**State Significant Development Application Number SSD-10300**

**Coffs Harbour Cultural and Civic Space.**

GORDON ST ELEVATION
ISSUE

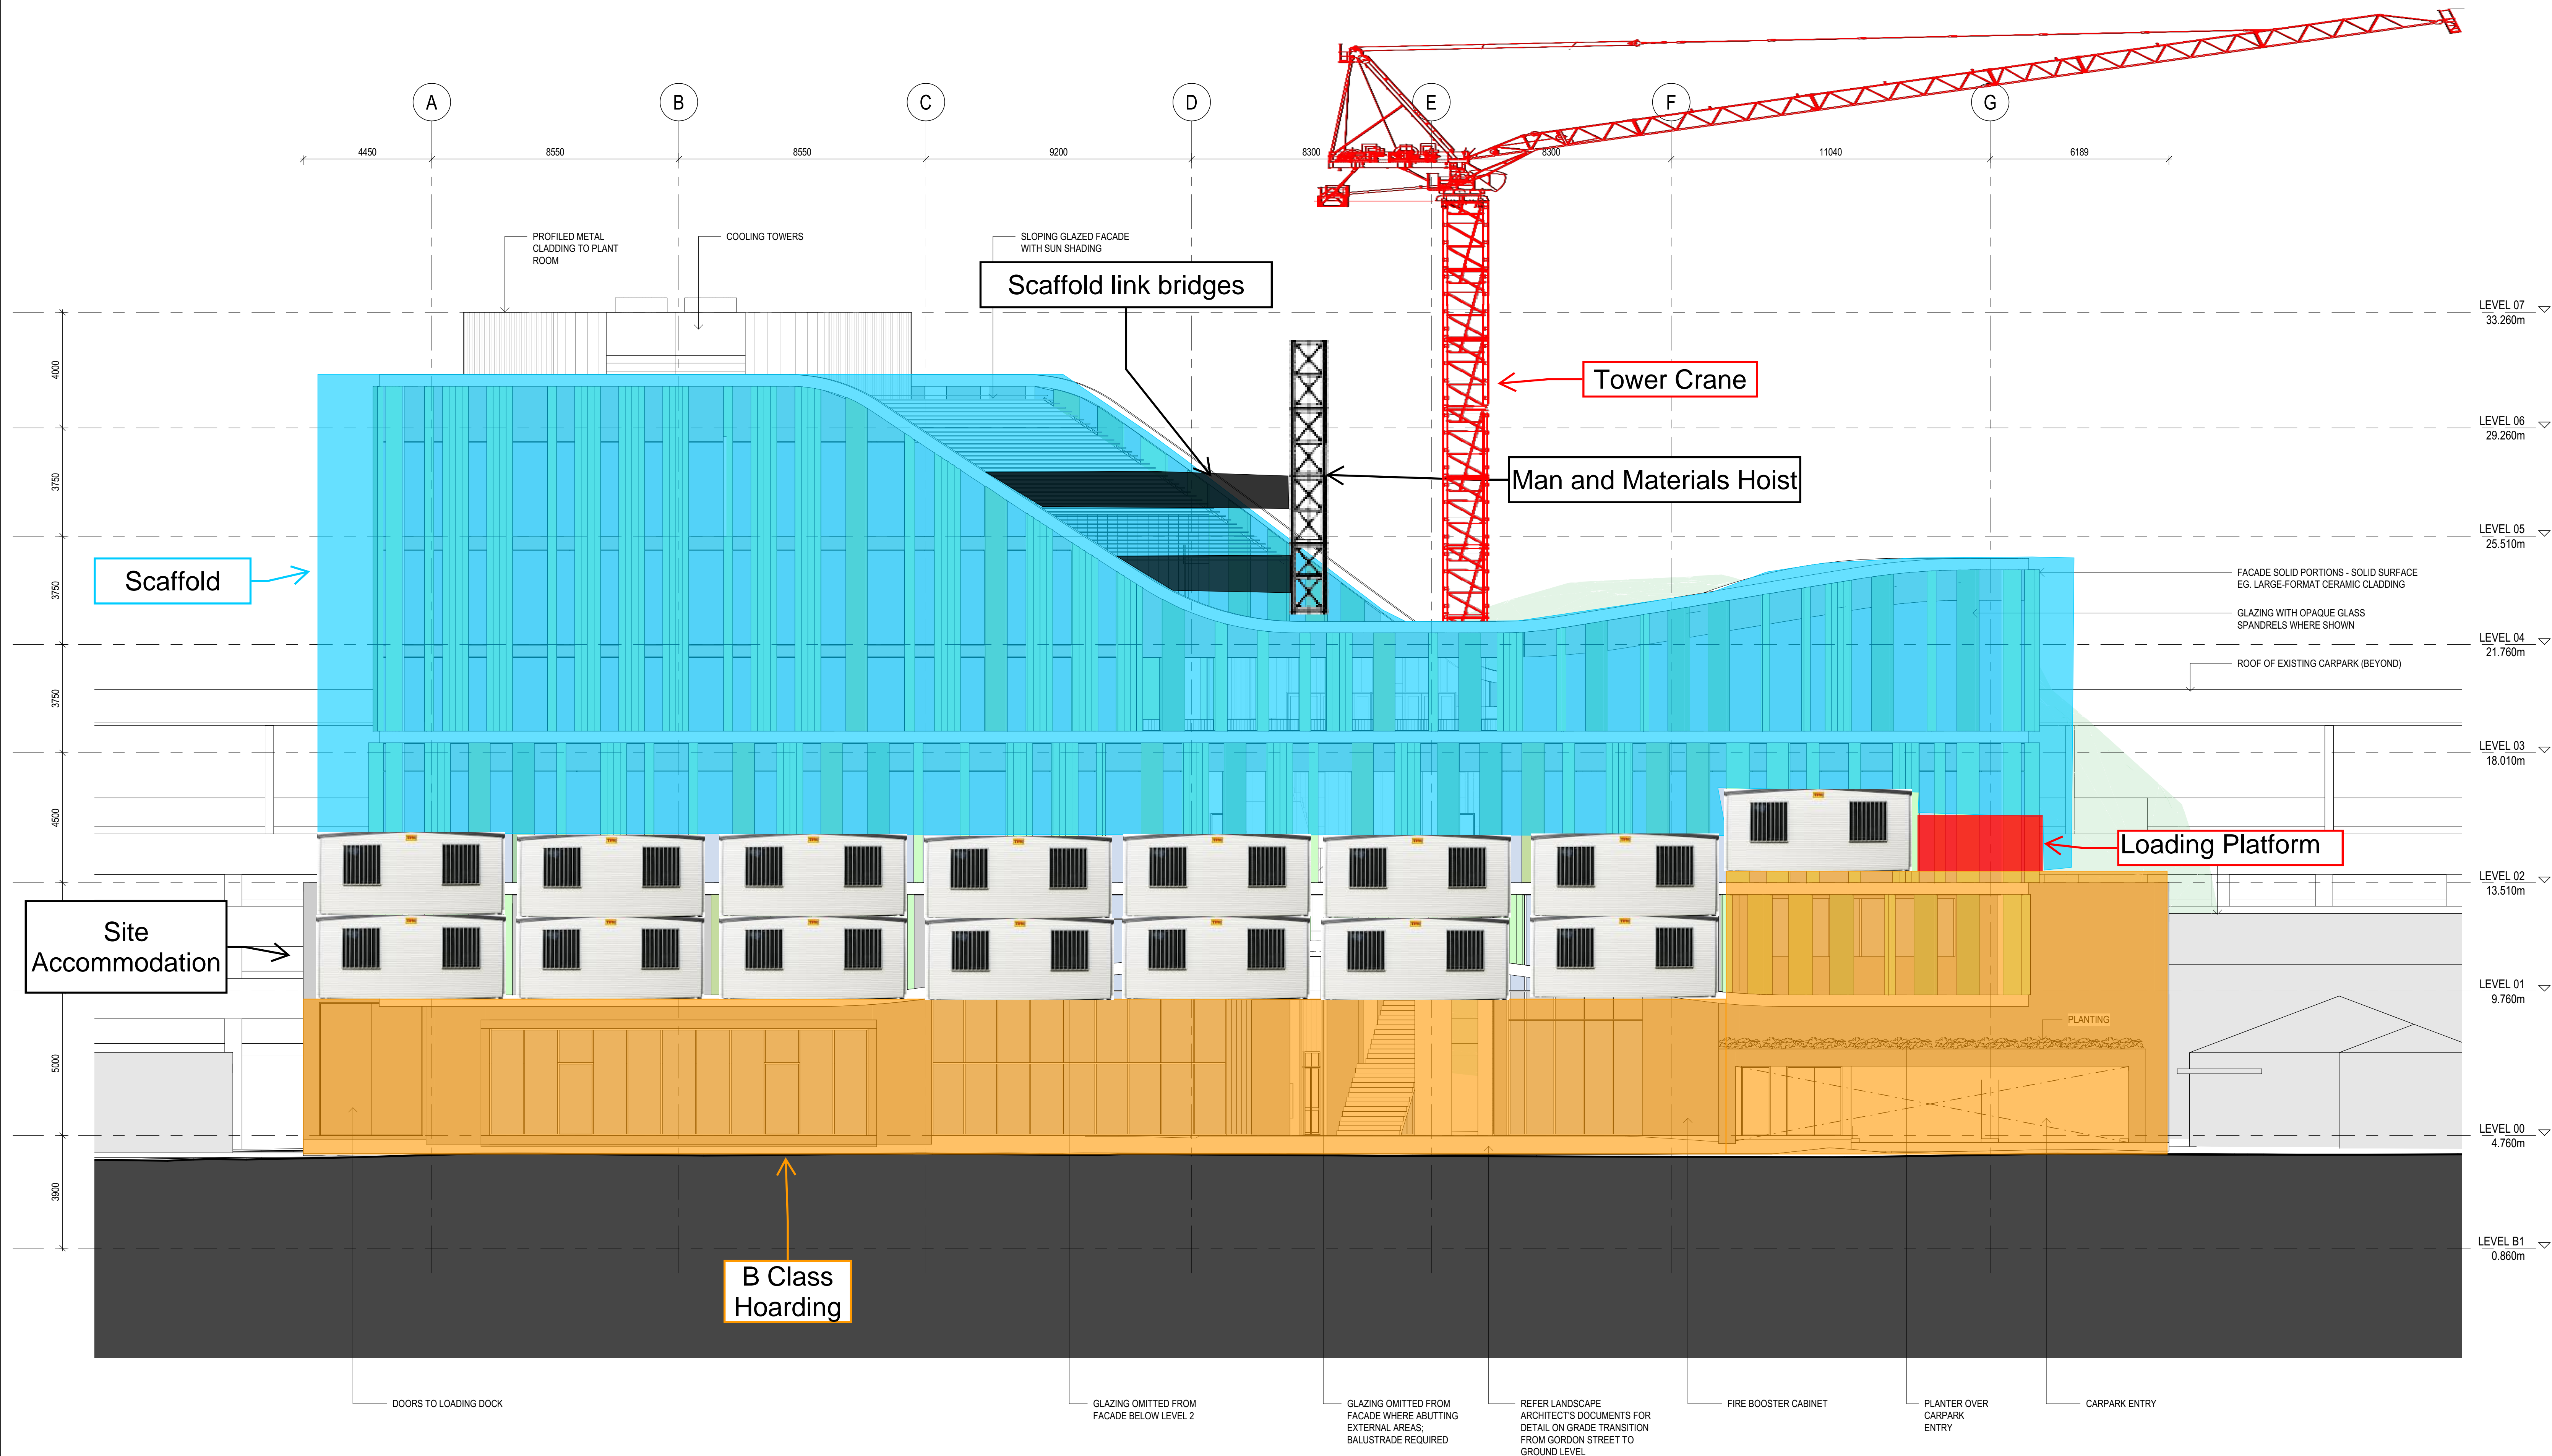
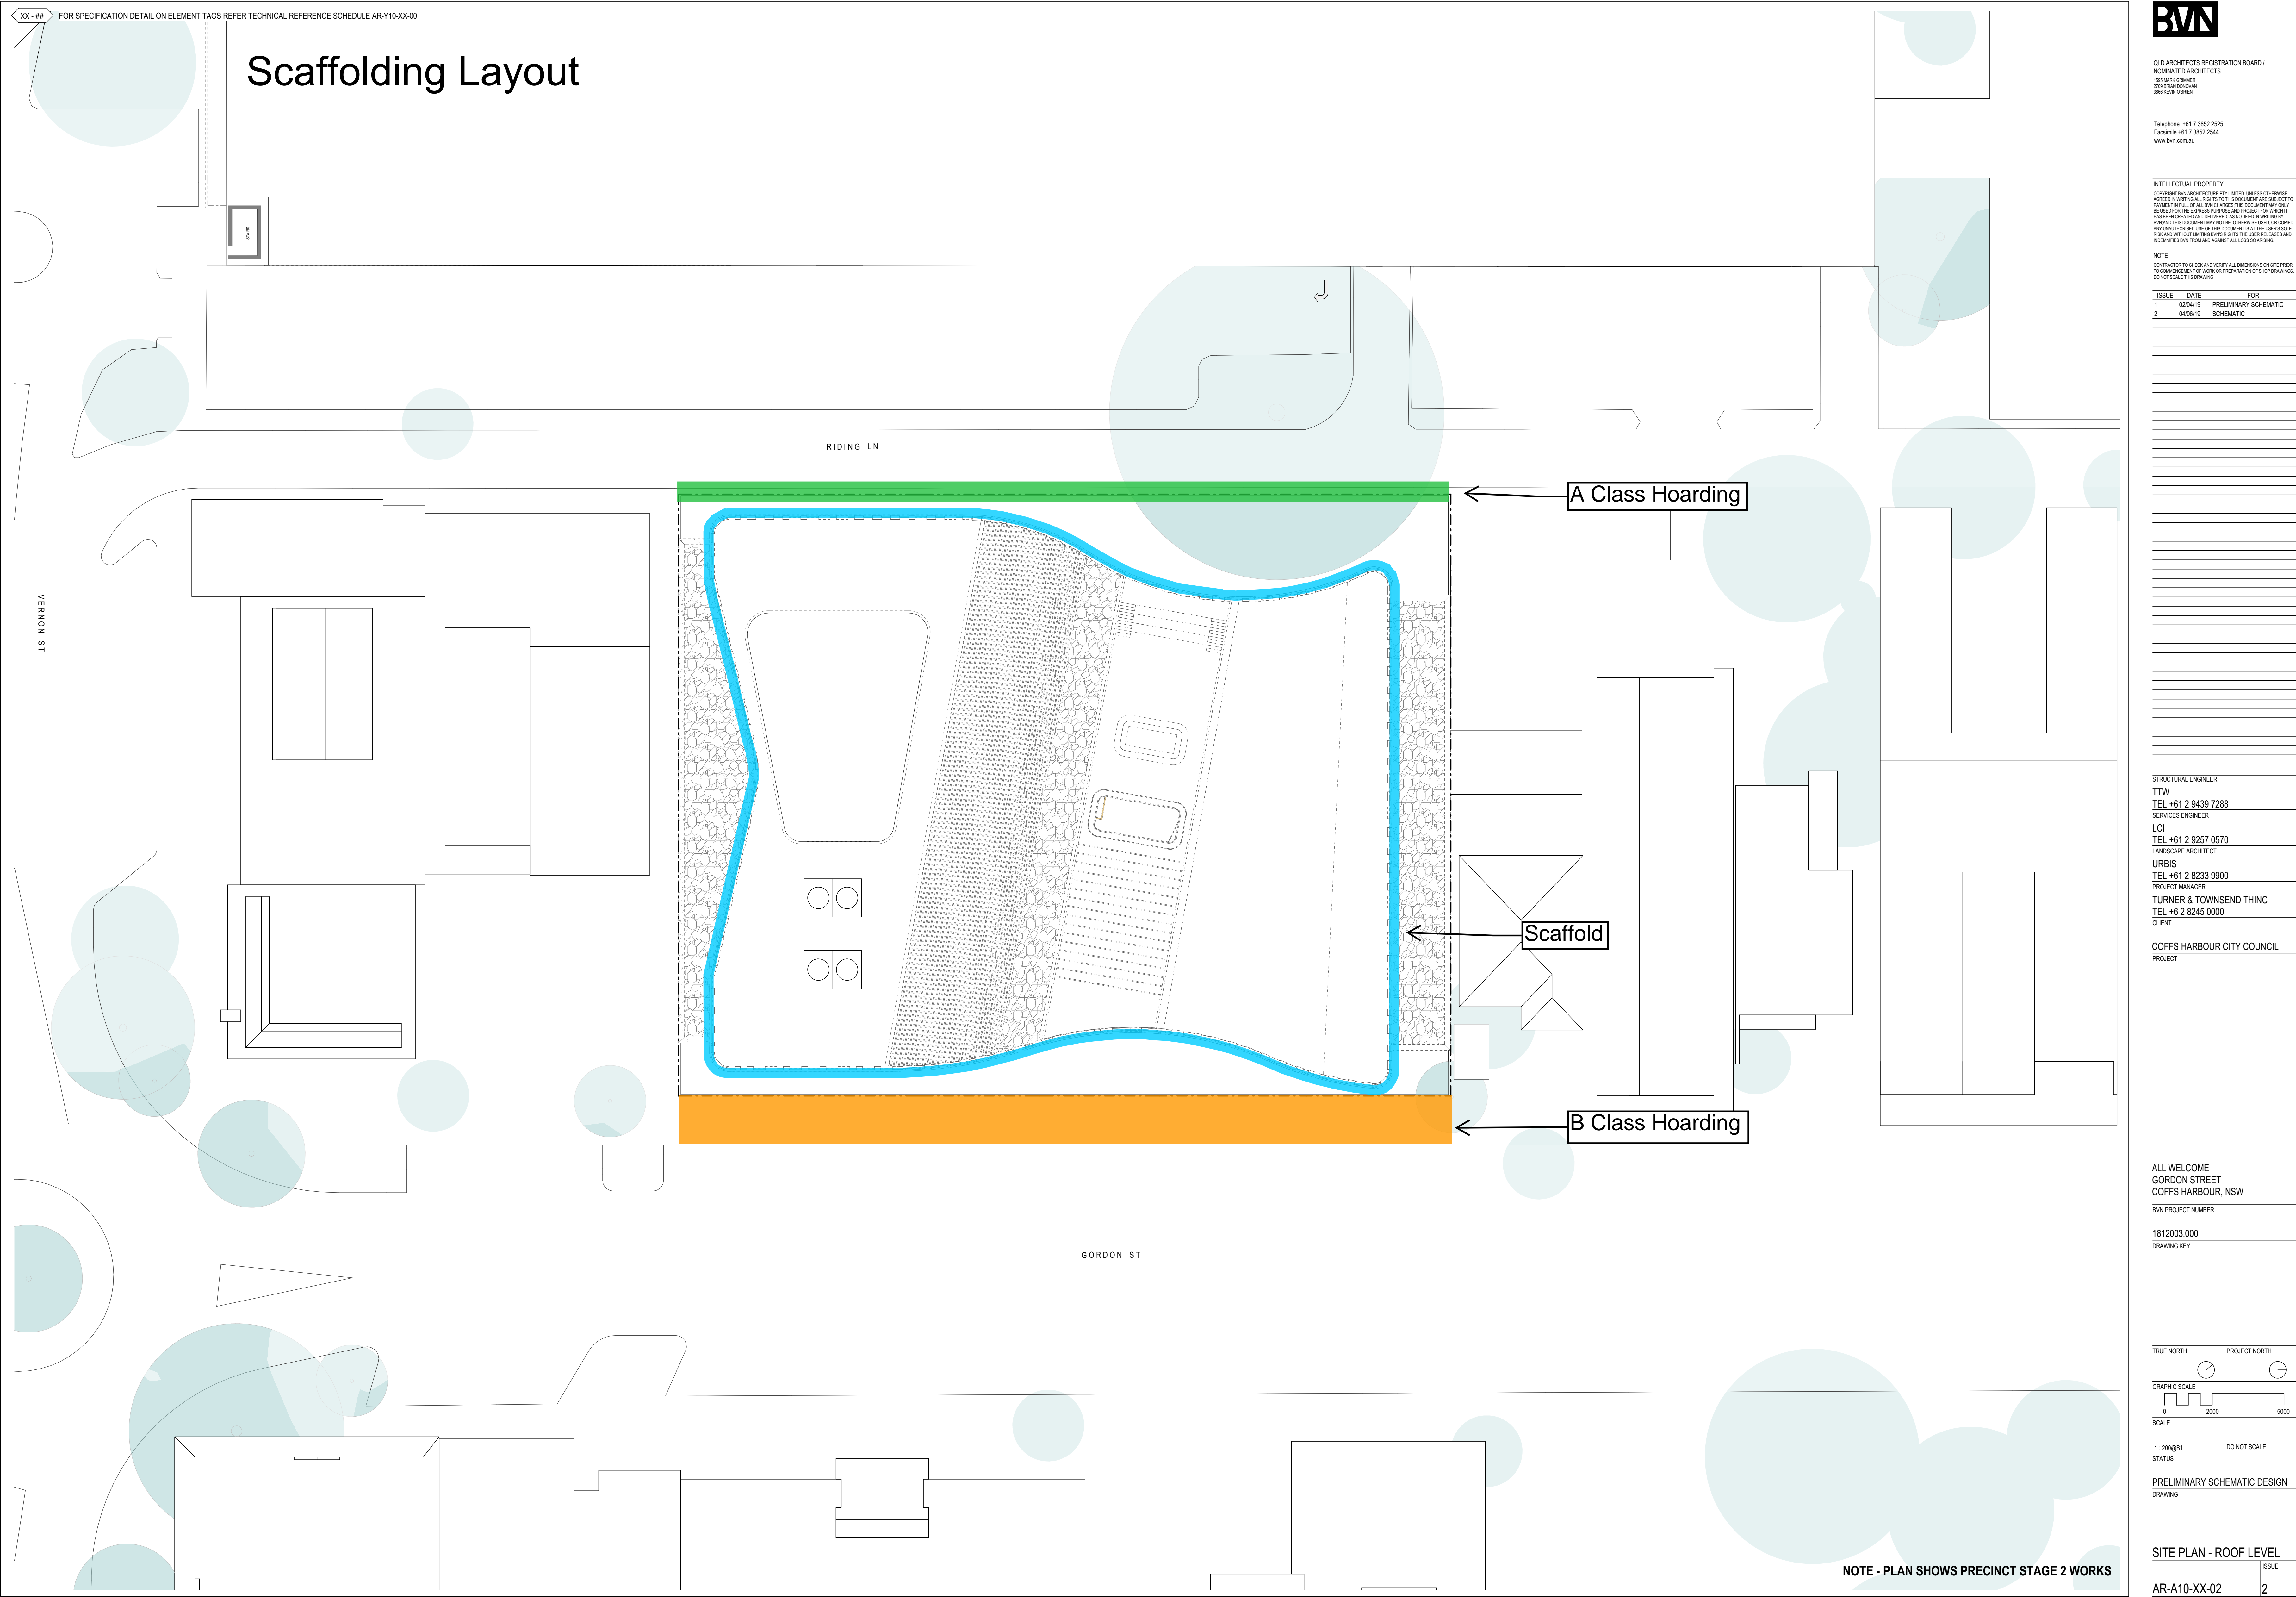
9. it conflicts with the streetscape of Gordon St in that the proposed building is outside the context of this street, having regard to the scale, existing street setbacks, design and general form of the adjoining buildings;

11. it exceeds the height limit of 28 metres as set down by Council, and an exception is not justified;
